Re: Quinn Ave Short Plat (SP23002)

Thank you for your preliminary short subdivision submittal. After technical review of the proposed short subdivision, the Planning Division offers the following comments:

RE: Quinn St SP, File# SP23-002
2 Lot Short Plat
940 Quinn Street & Parcel # 00465200100800

PRELIMINARY SHORT PLAT MAP
SHEET SPI of 1

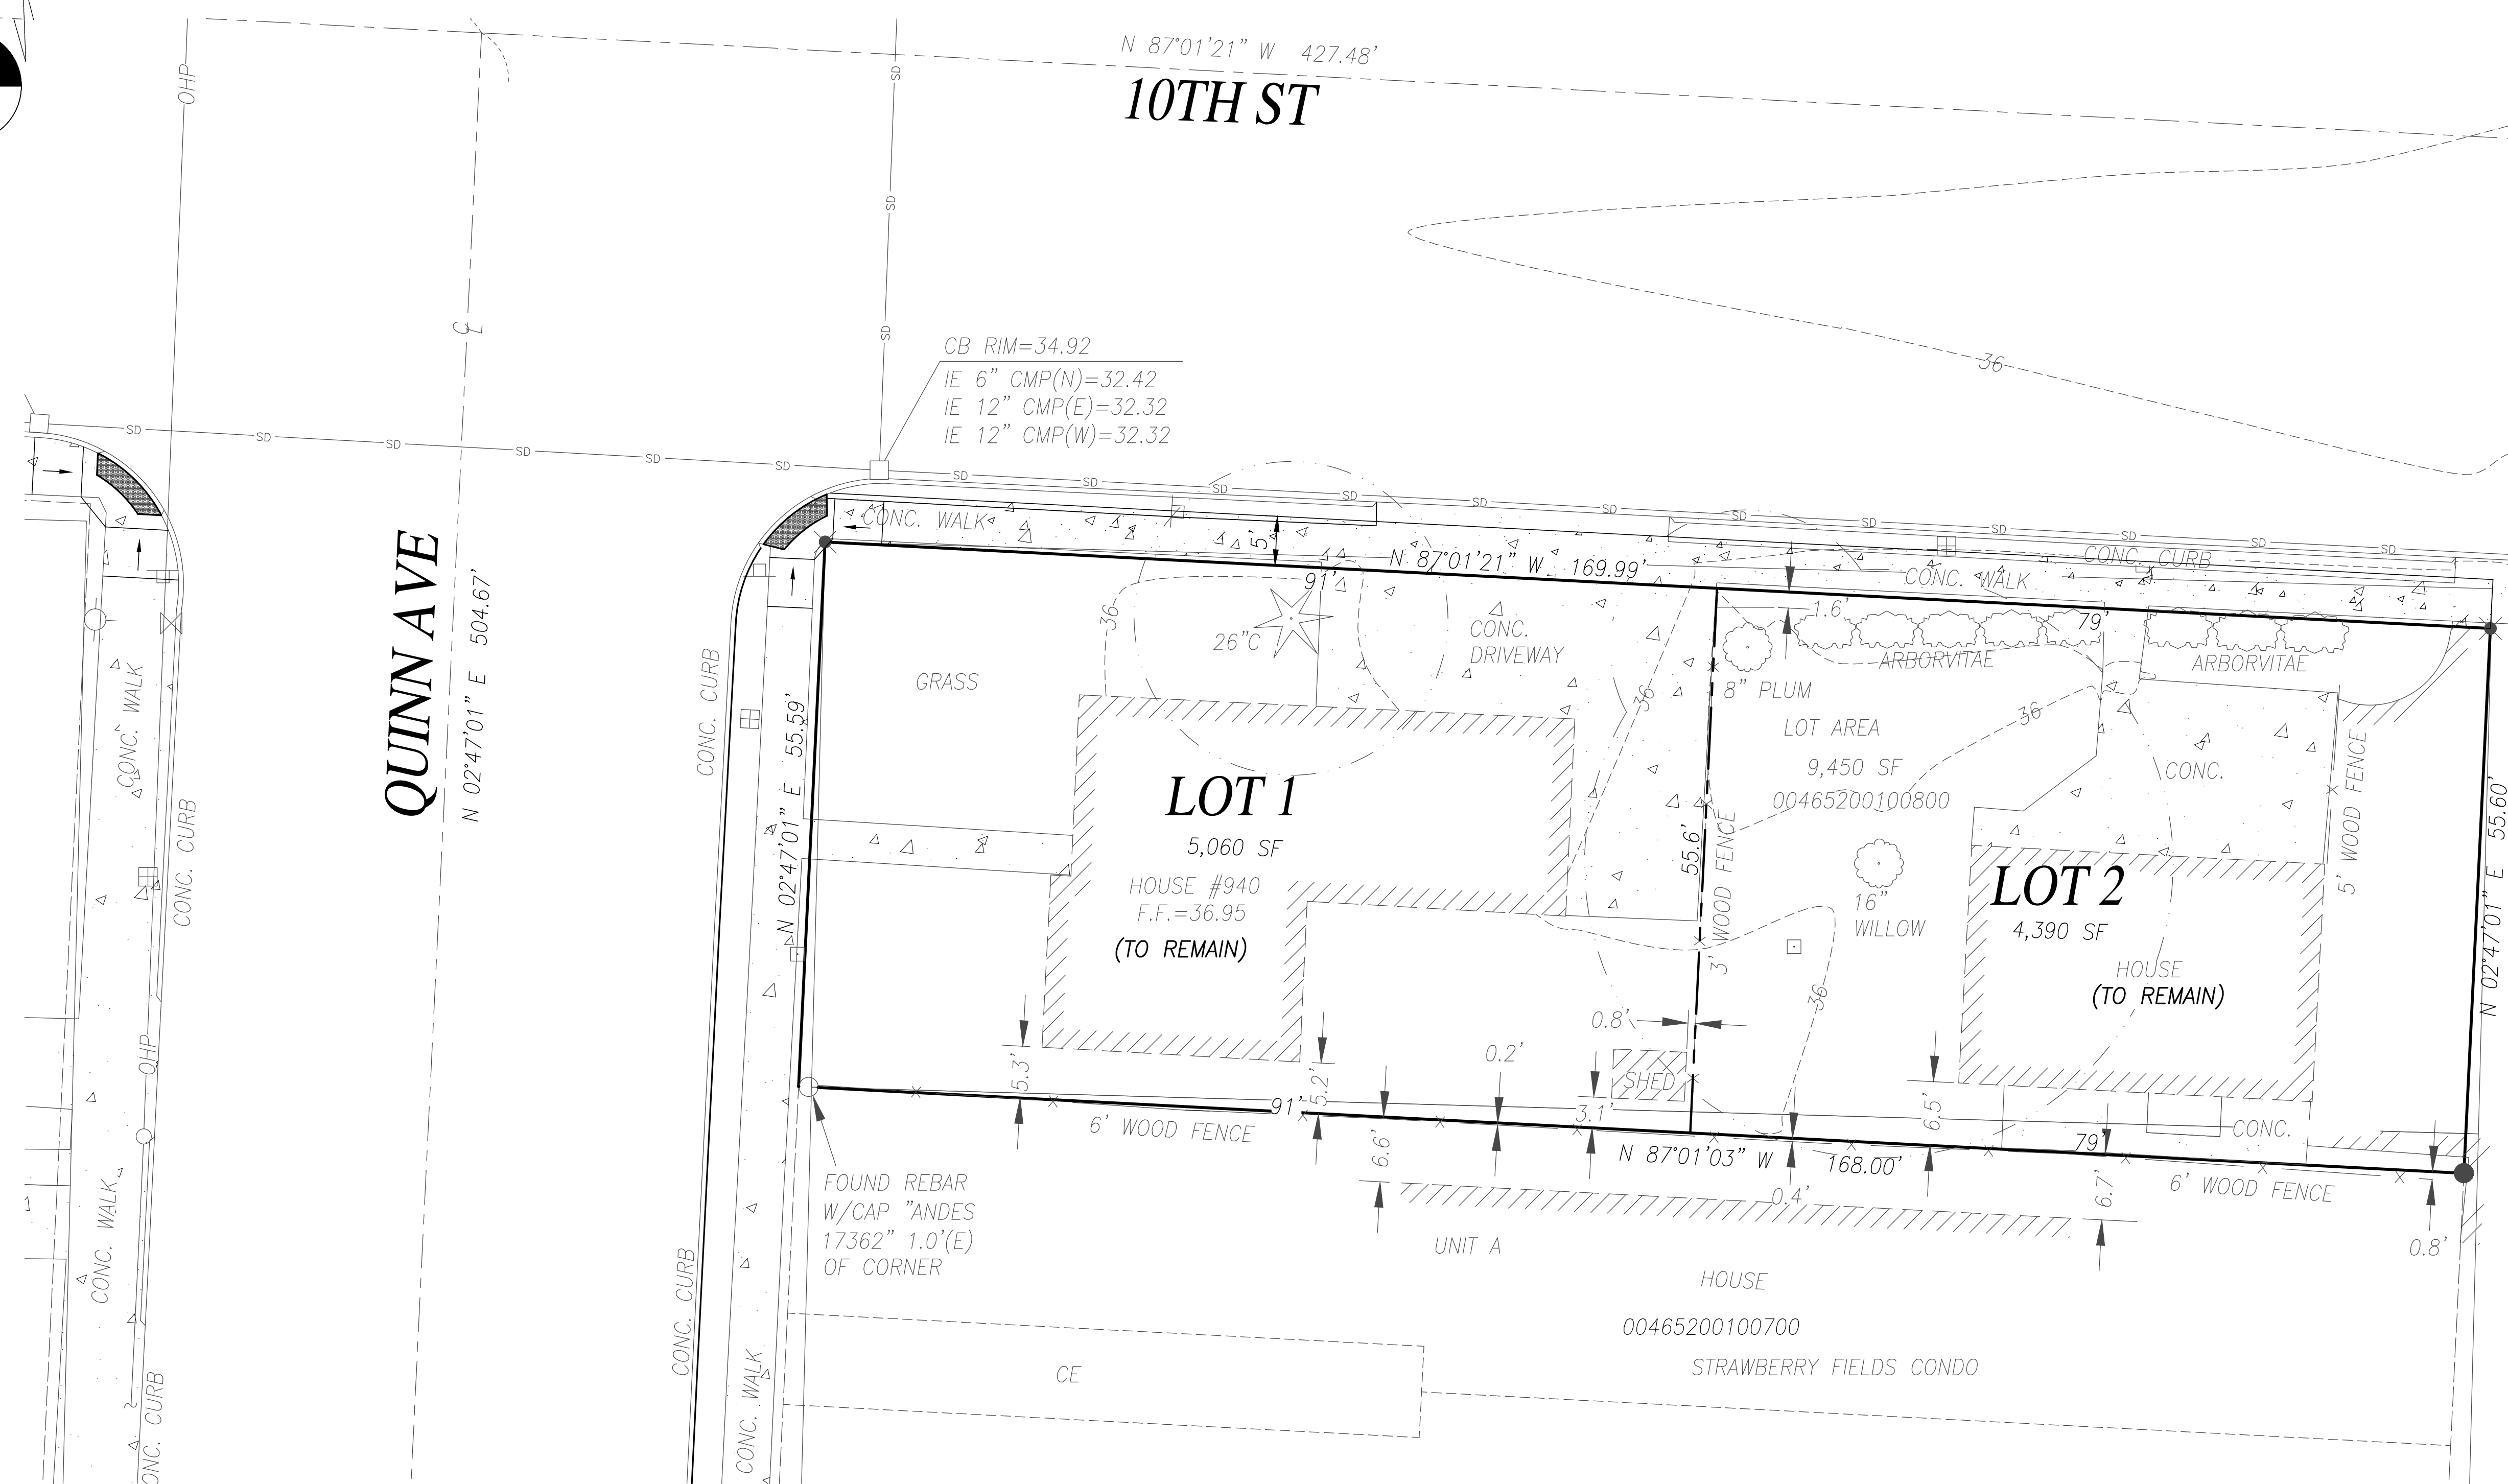
1. Please include file number SP23-002 on all future maps.
2. Amend the preliminary short plat map, as follows:
 - a. Change 'PERCEL NUMBERS' to 'PARCEL NUMBERS';
 - b. Remove the parking stall numbers and solid black lines;
 - c. Remove the building setback lines;
 - d. Provide the following note:

The existing structures are considered legal nonconforming structures and uses and are subject to the provisions outlined in MMC Chapter 22C.100 *Nonconforming Situations*.

3. The existing shed located on the south-east portion of Lot 1 does not comply with the required minimum 5 foot side and rear yard setbacks and may be considered a legal nonconforming structure. Pursuant to MMC 22G.090.550, when divisions or redivisions of land are submitted proposing the creation of new lots with existing structures, the existing structures shall comply with all zoning code requirements including, but not limited to, such things as setback requirements, parking requirements and height standards; provided, however, if the structures are legal nonconforming buildings, nothing shall prohibit the division of such land, so long as the division does not increase or intensify the nonconforming nature of the structure.

The applicant shall be required to demonstrate the shed was legally constructed, or reconstructed to comply with the required 5 foot setback, prior to recording the short plat.

PRELIMINARY SITE PLAN

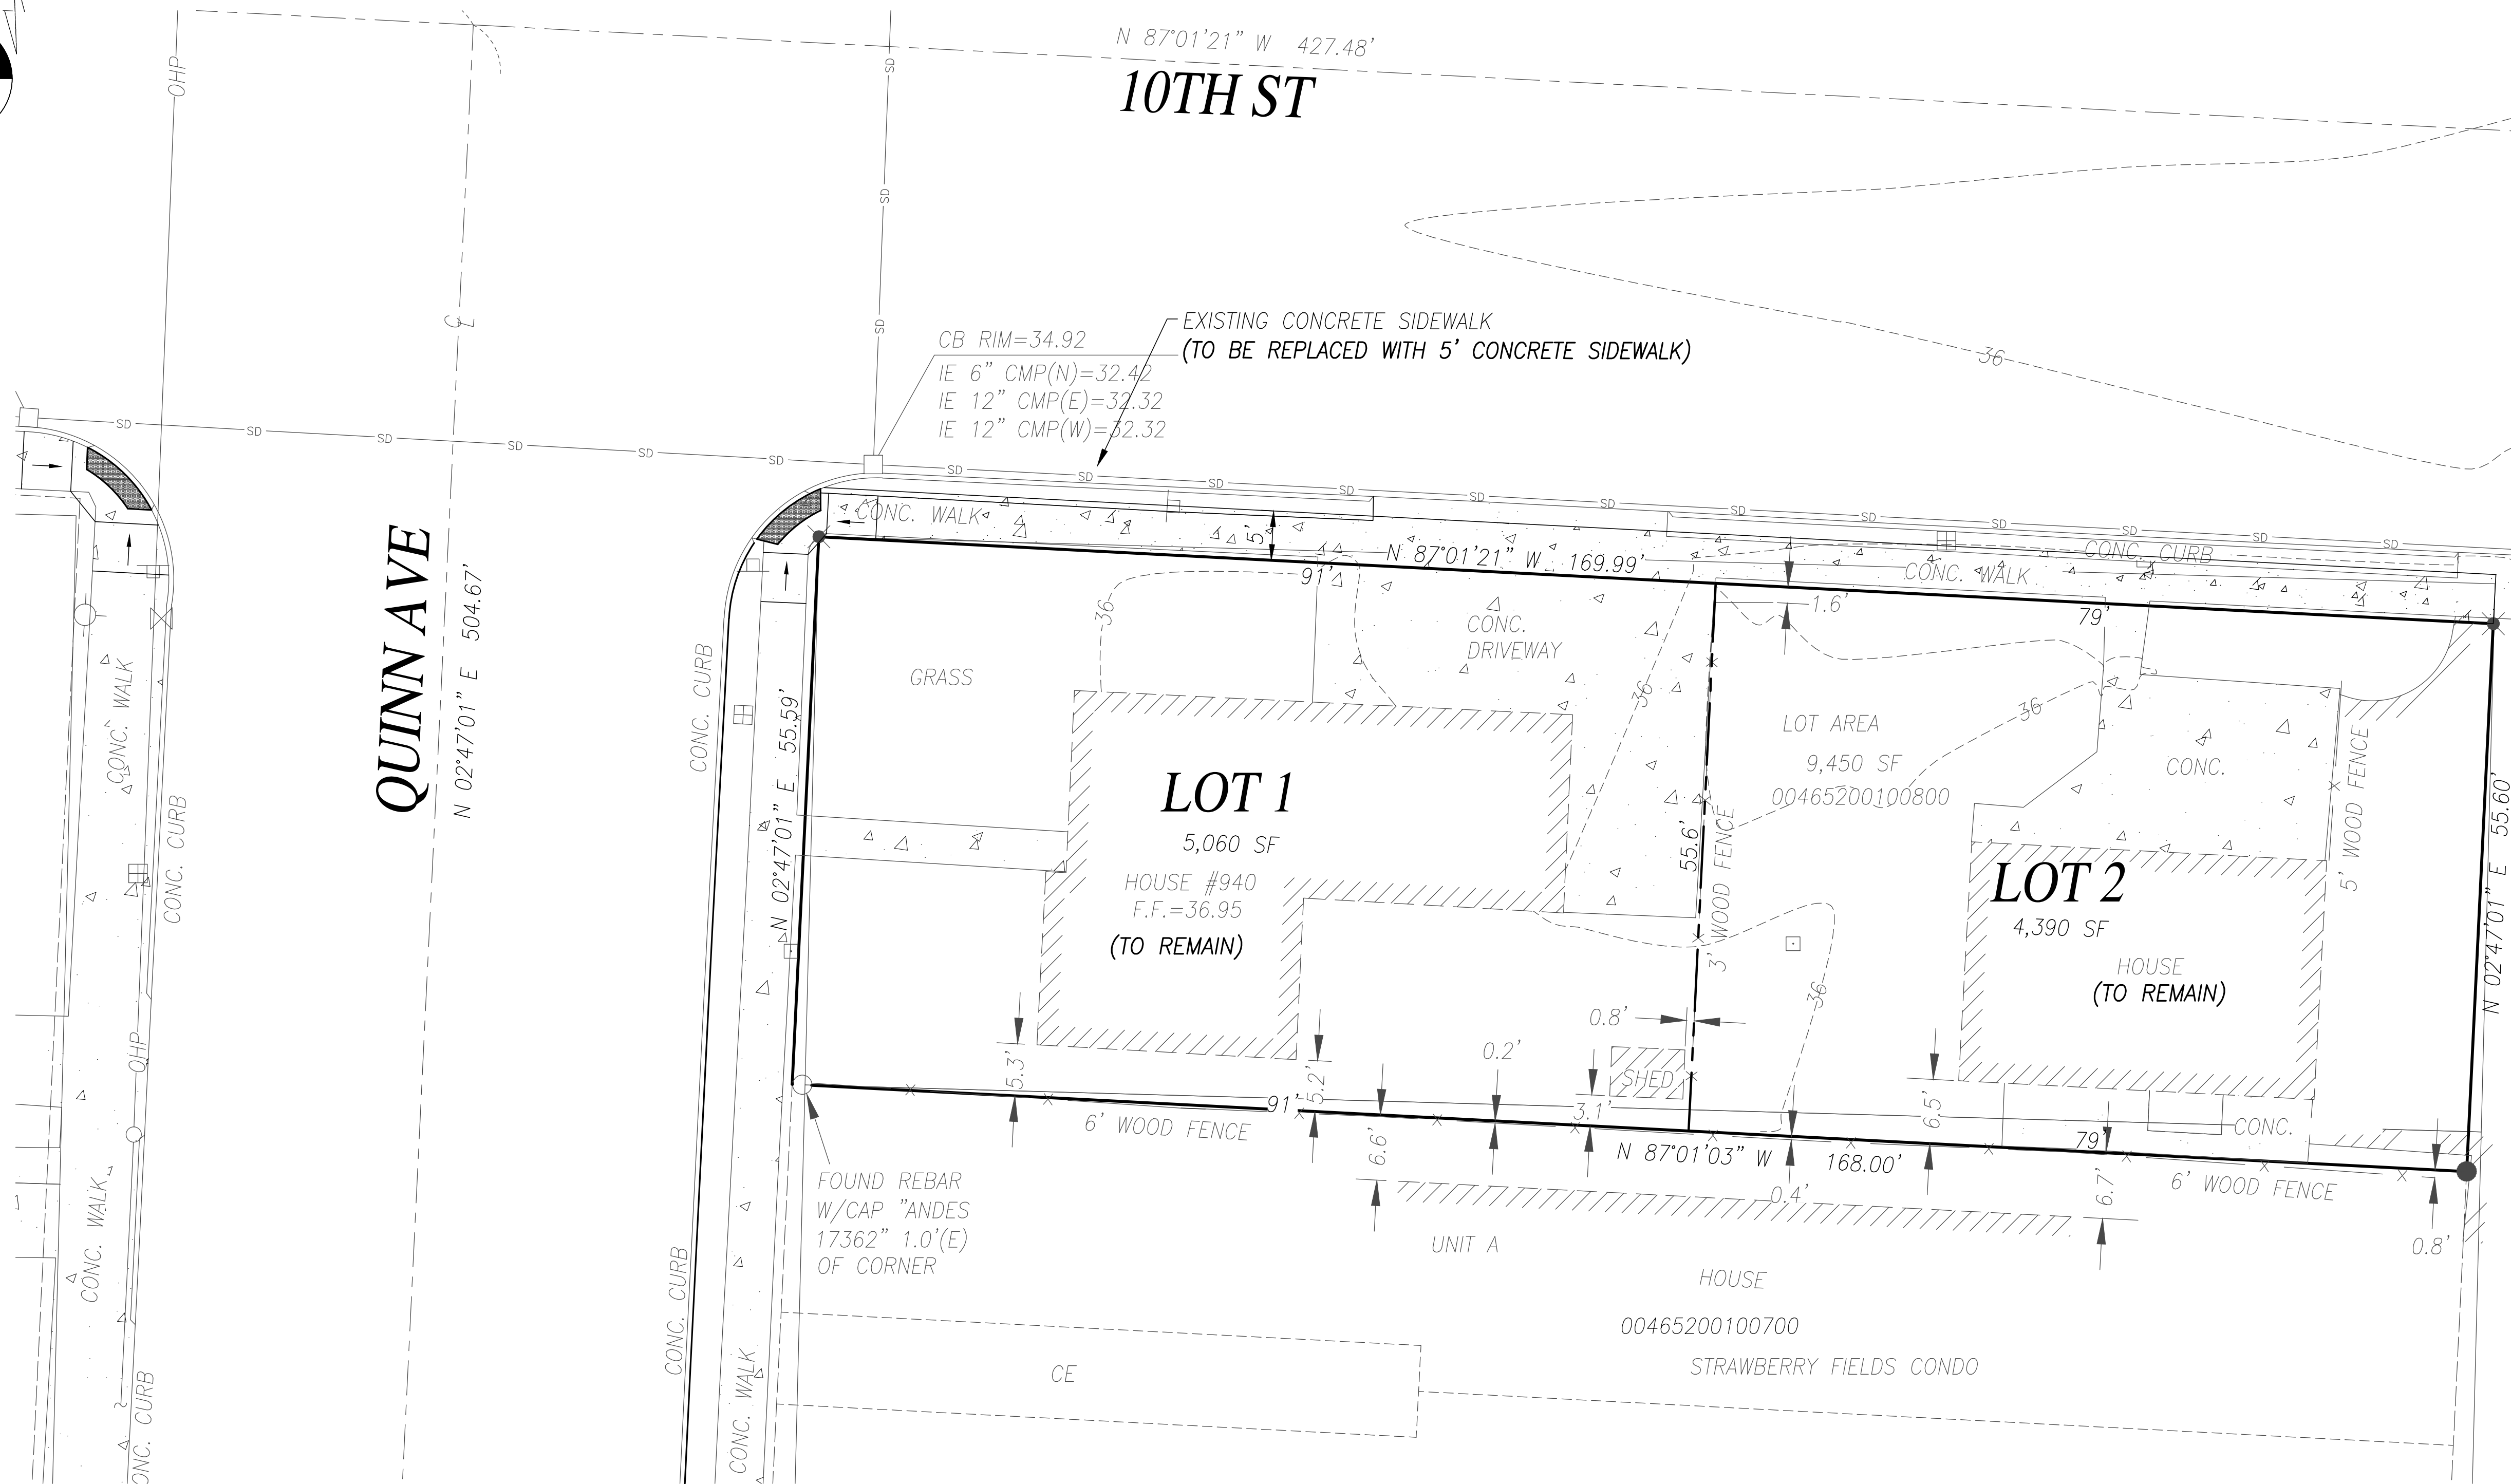
- a. At this time it looks like the roadway is expanded to the City standard. The sidewalks fronting the parcel should be removed and replaced with a 5 foot wide sidewalk.

9. Currently the lot has only 1 water meter. The project will need to install an additional water meter.
10. The 2 existing structures may be sharing the same side sewer hookup. At a minimum an easement will need to be placed, and possibly a new tap into the sewer in the alley.
